RIBBLE RIVERS TRUST

2 July 2013

Application 3/2013/0550 – demolition of Rabeck House, Sawley and the construction of 3 detached dwellings.

Proposed Site Layout

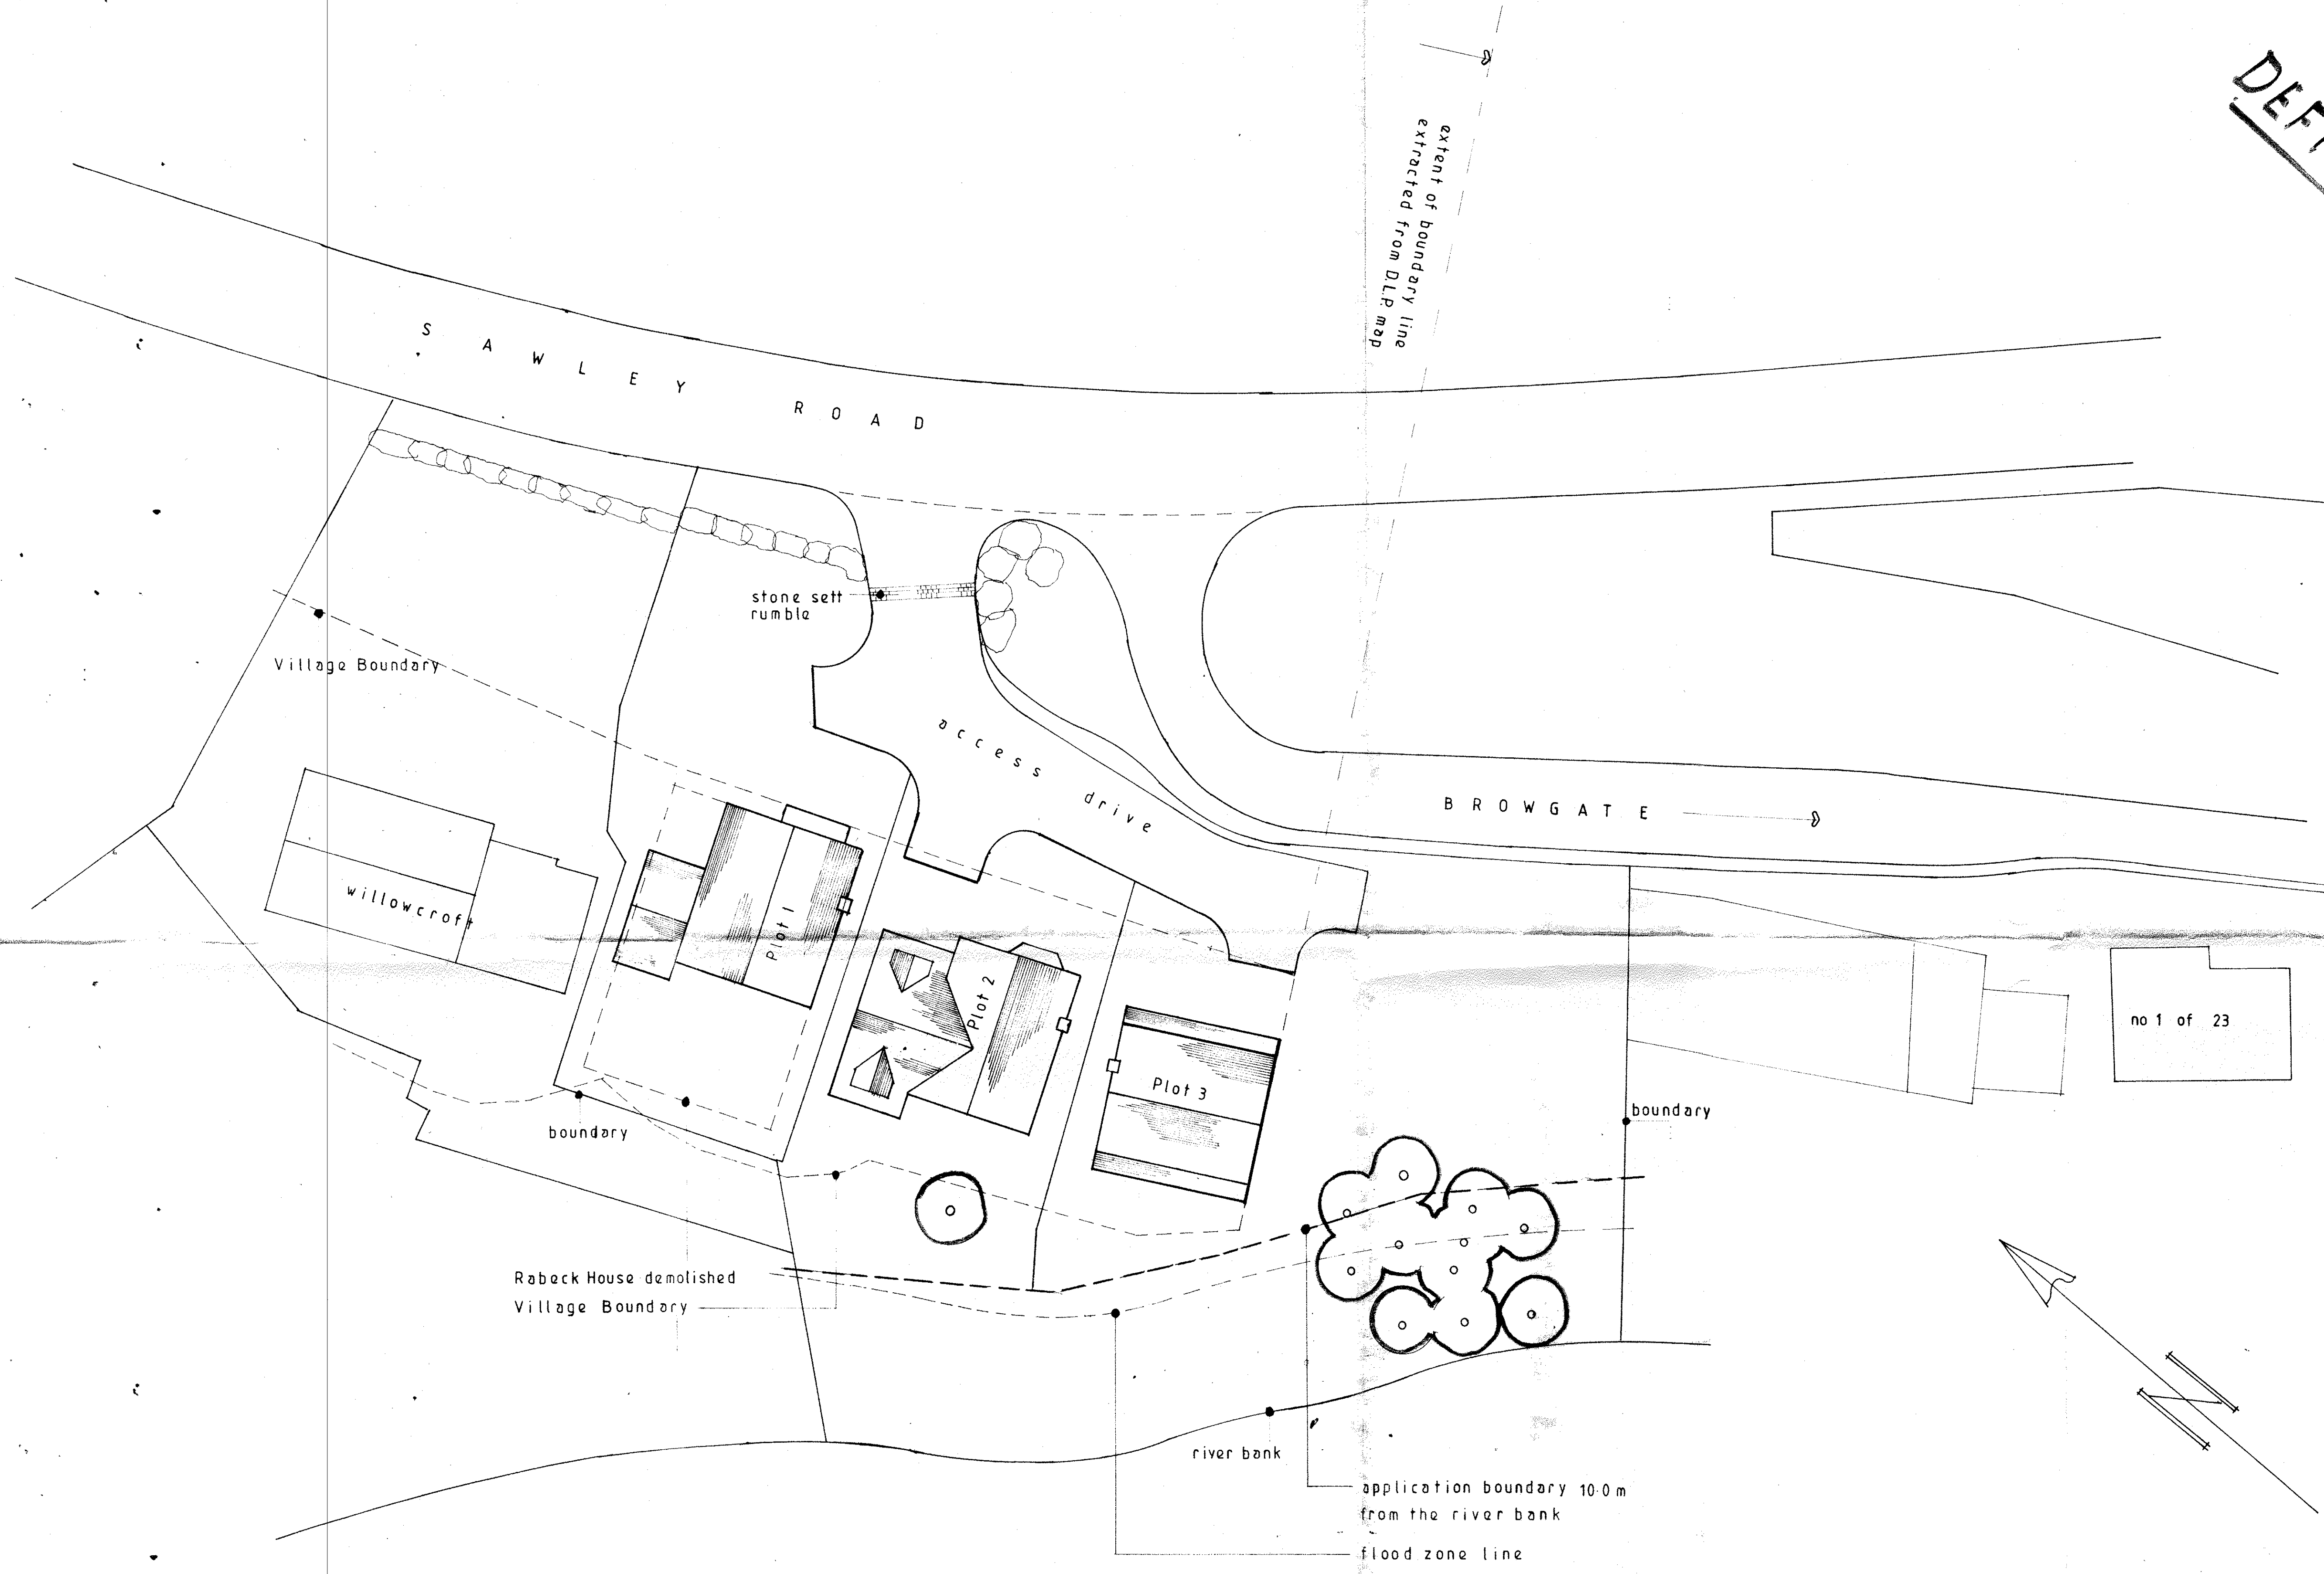
Appropriate pollution prevention measures need to be in place during site construction to prevent any pollution incidents arising from sediment and or fuel oil entering the watercourse. As the proposed development site slopes towards the River Ribble then it is assumed that this development with contain some form of SUD to take into account the surface water drainage from the site.

The Rivers Trust Salmon Tracking studies have shown that this is an important area used by salmon. Any site works near to this location are likely to cause disturbance. Light pollution from dwellings in this location are likely to have an impact on the river and the riparian habitat so appropriate measures should be included to ensure no impact on the river or riparian habitat (these could include screening, and riparian habitat improvements for mitigation).

S.J. Biłocki Limited Building Surveyors
Drawing no 6013
Scale 1:200
Tree Survey
Proposed Housing Development On Land At Rabcock House Sawley Road Sawley

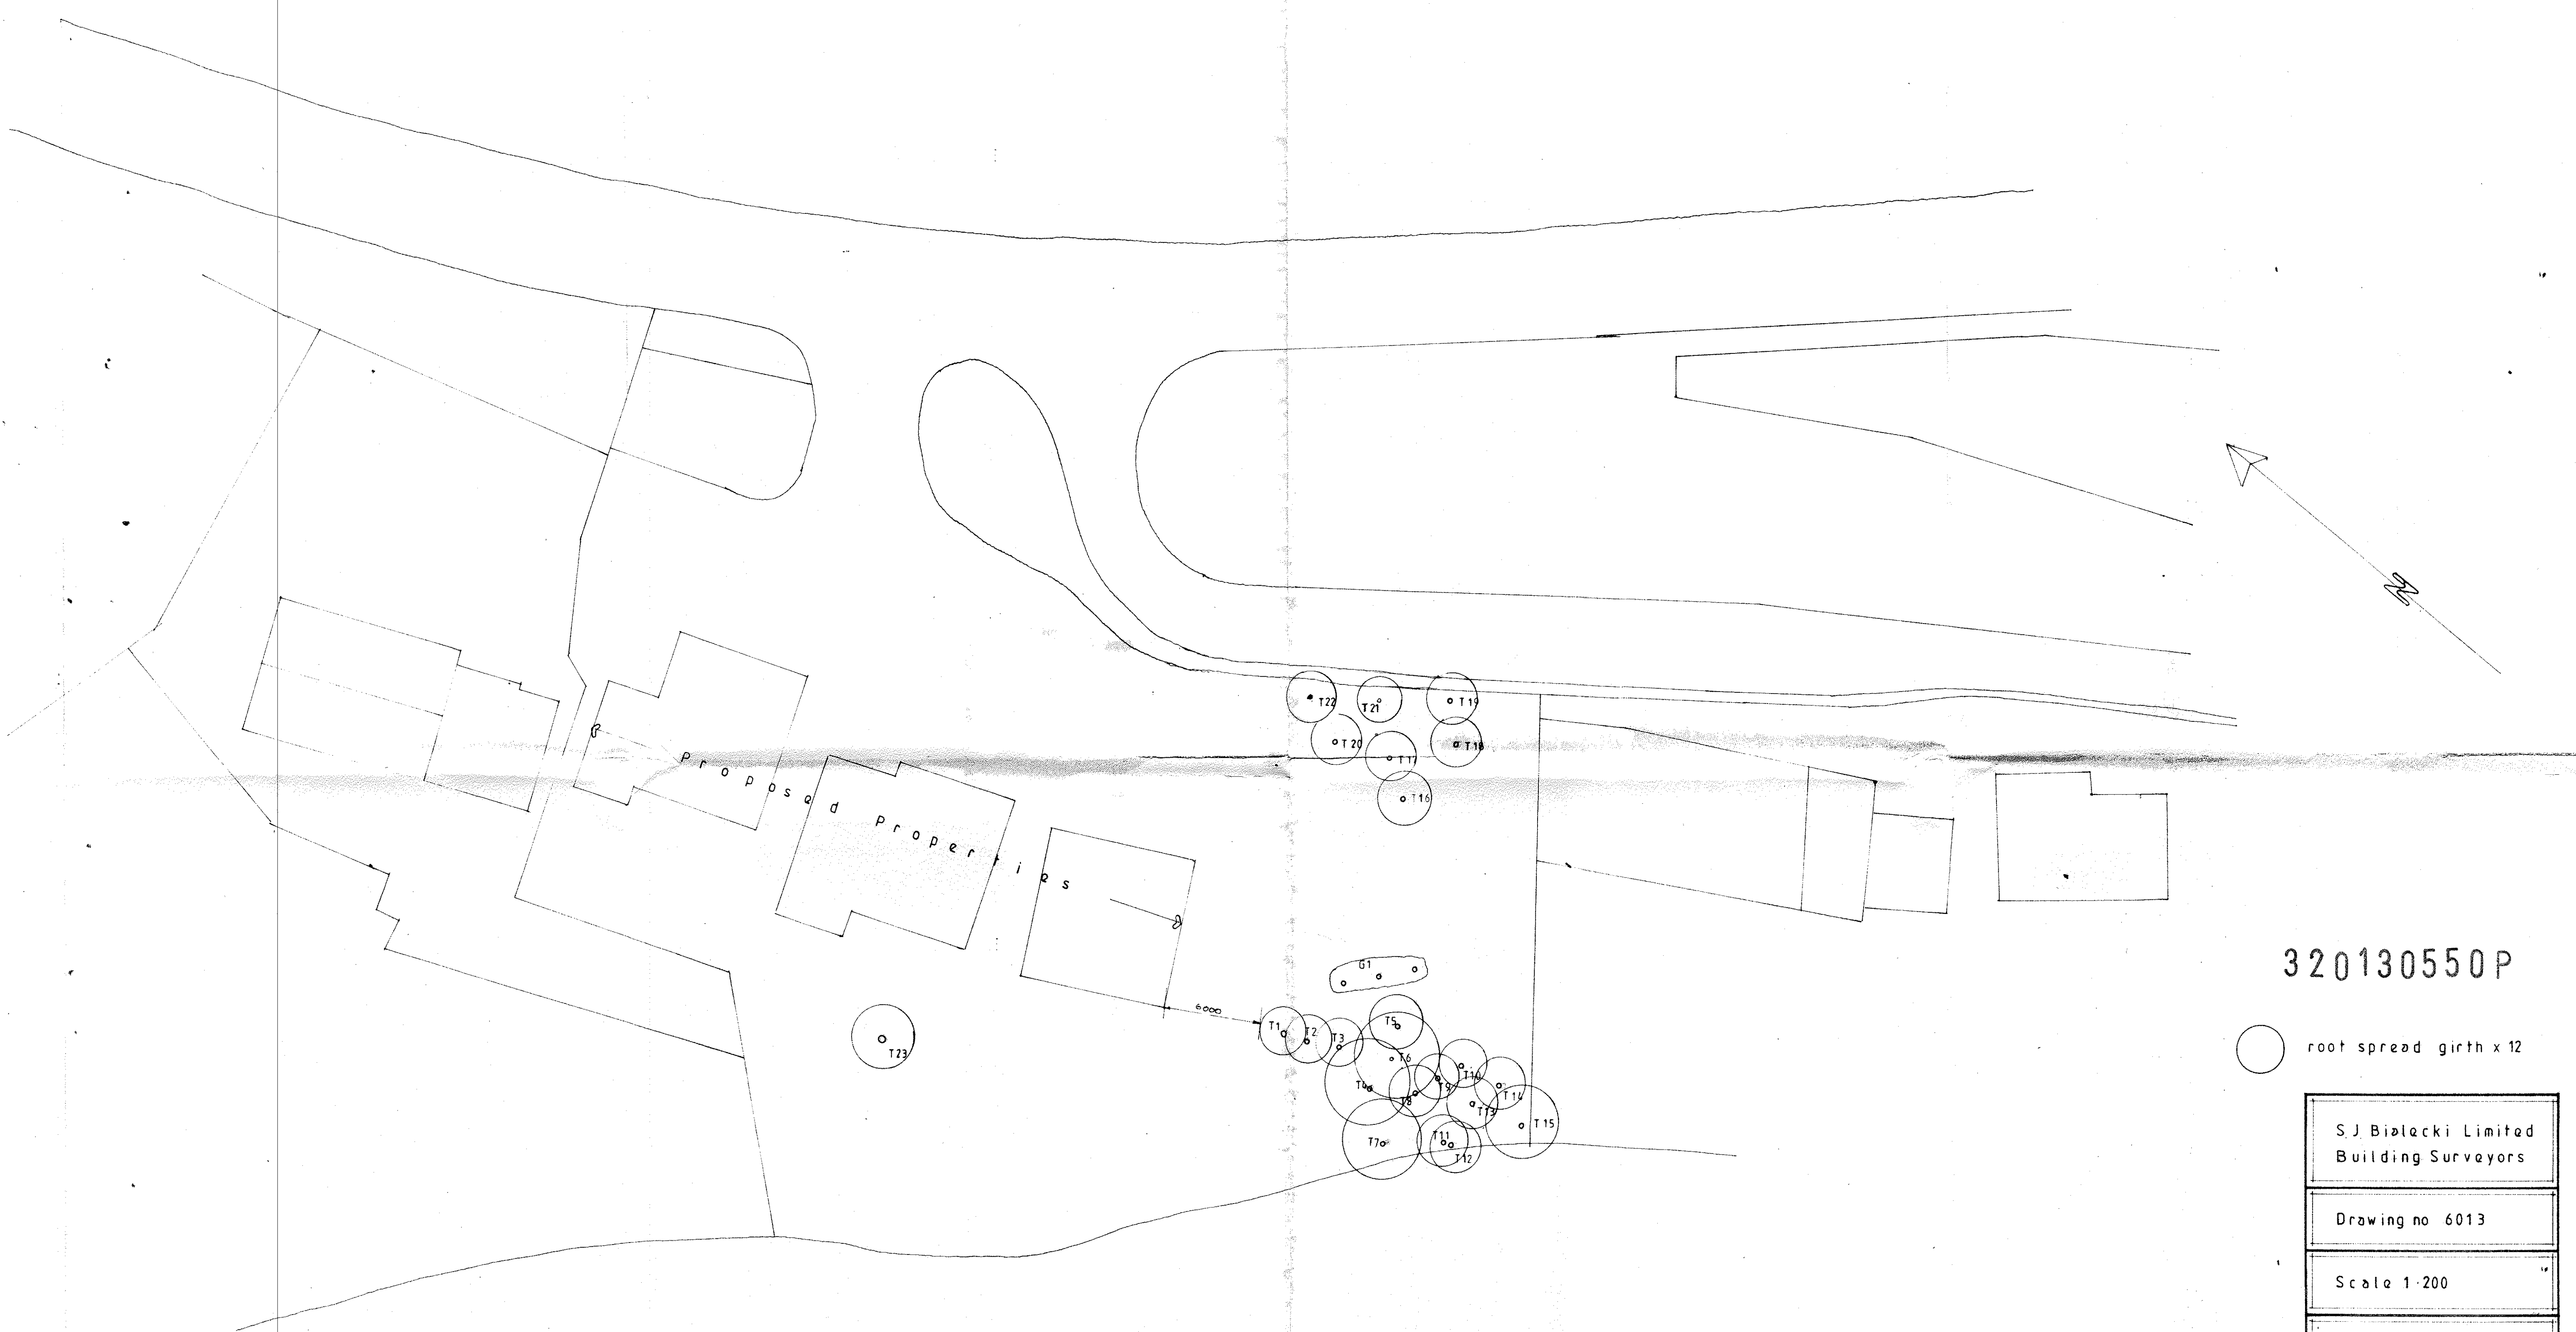
There is no ecological report attached to the application – only a tree survey?
